DECISION DELEGATED TO DEVELOPMENT MANAGER
--

Application No:	H06-0829-19	Applicant:	C R Cunnington & Son Ltd
Proposal:	Change of use of agricultural building into dwelling		
Location:	Land Off: Green Dyke Gedney Dyke Spalding		
Terminal Date:	17th October 2019

DRAWING PLAN/ELEVATIONS

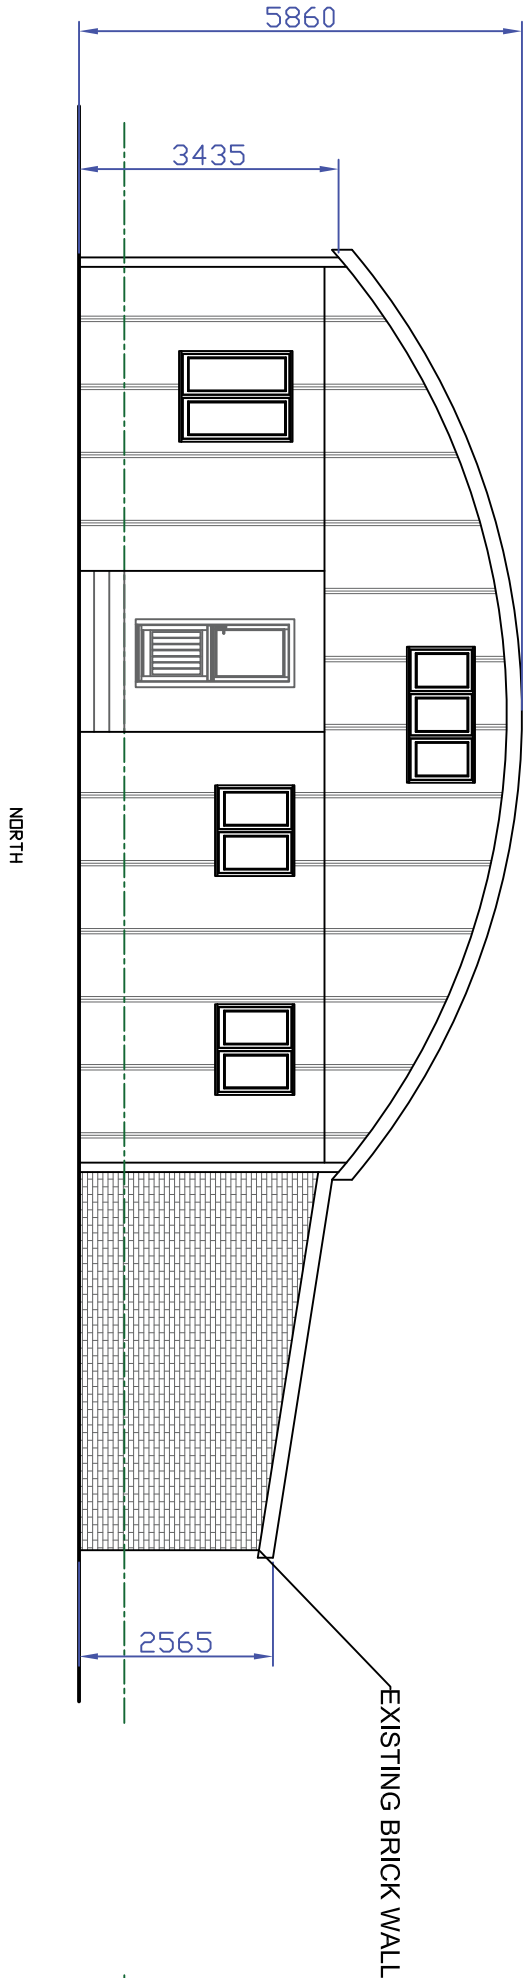
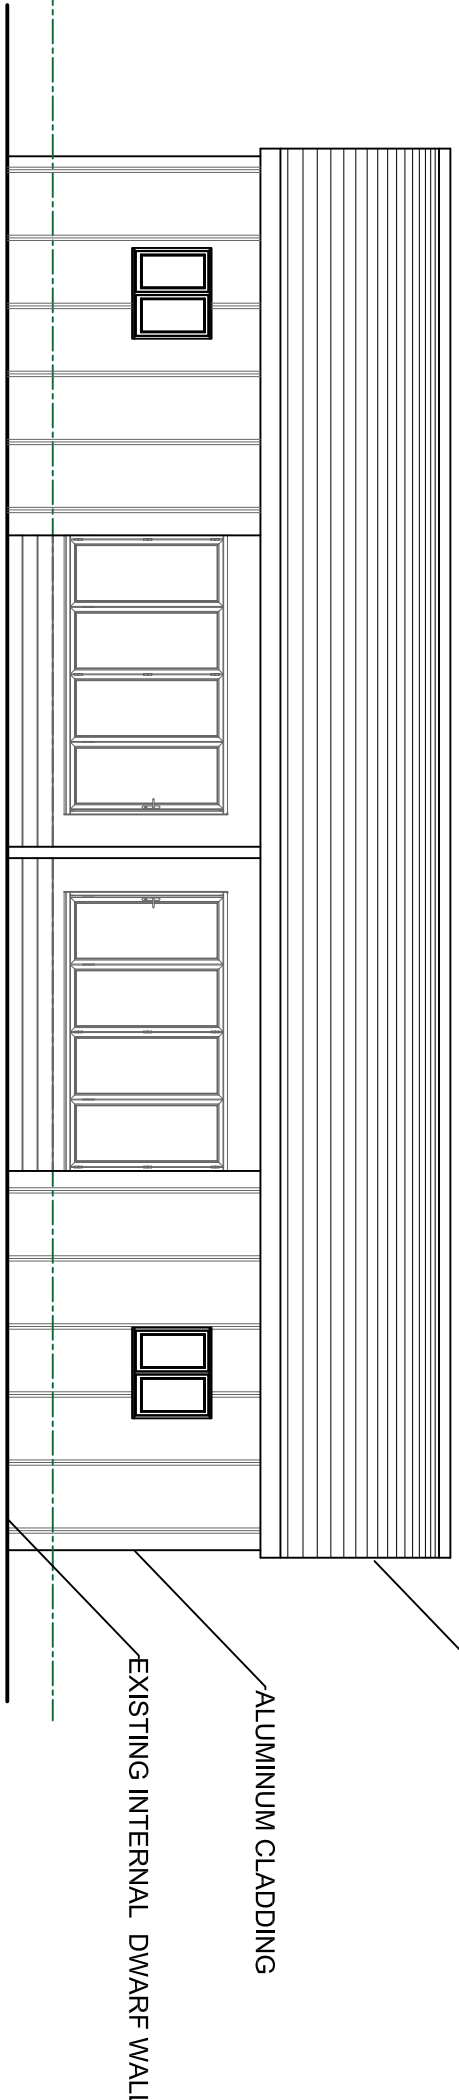
Notwithstanding the amended plans the Environment Agency has objected on grounds that the submitted Flood Risk Assessment (FRA) does not adequately assess the flood risks posed by the development. The FRA is for a 2-storey dwelling whereas the plans supporting the application are for a single storey dwelling with ground floor sleeping accommodation.

The Environment Agency has indicated that it will only support like-for-like vulnerability classification uses and may not support proposals including ground floor habitable accommodation, as is the case in this situation. The FRA should aim to identify mitigation measures in line with those required for new build development of the same type, as far as this is practicable.
